# **Written Representations 1**

## **Application by ESSO Petroleum Company Ltd for an Order Granting Development Consent for the Southampton to London Pipeline Project**

**Application Reference EN070005  
Interested Party Reference 20022787  
Internal Reference 19/00432/PINS**

Illustration 3.2: Outline proposal for Cove Brook Dam crossing

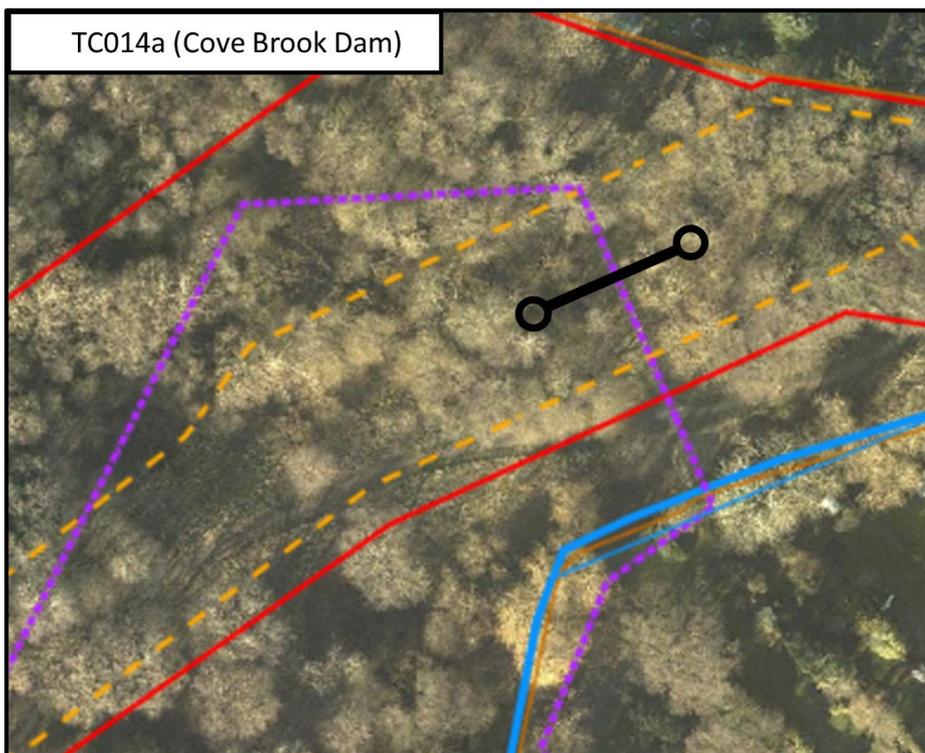
- The EA have expressed concerns regarding plans to trench through the bund within the flood mitigation area in Southwood Country Park as it will undermine the integrity of area and could negate its flood storage function.
- RBC would fully support this view. The flood mitigation area stores water coming off the Country Park, the airport and acts as a storage area for excess water within the Basingstoke Canal. If the bund failed there would be extensive flooding within the urban area.
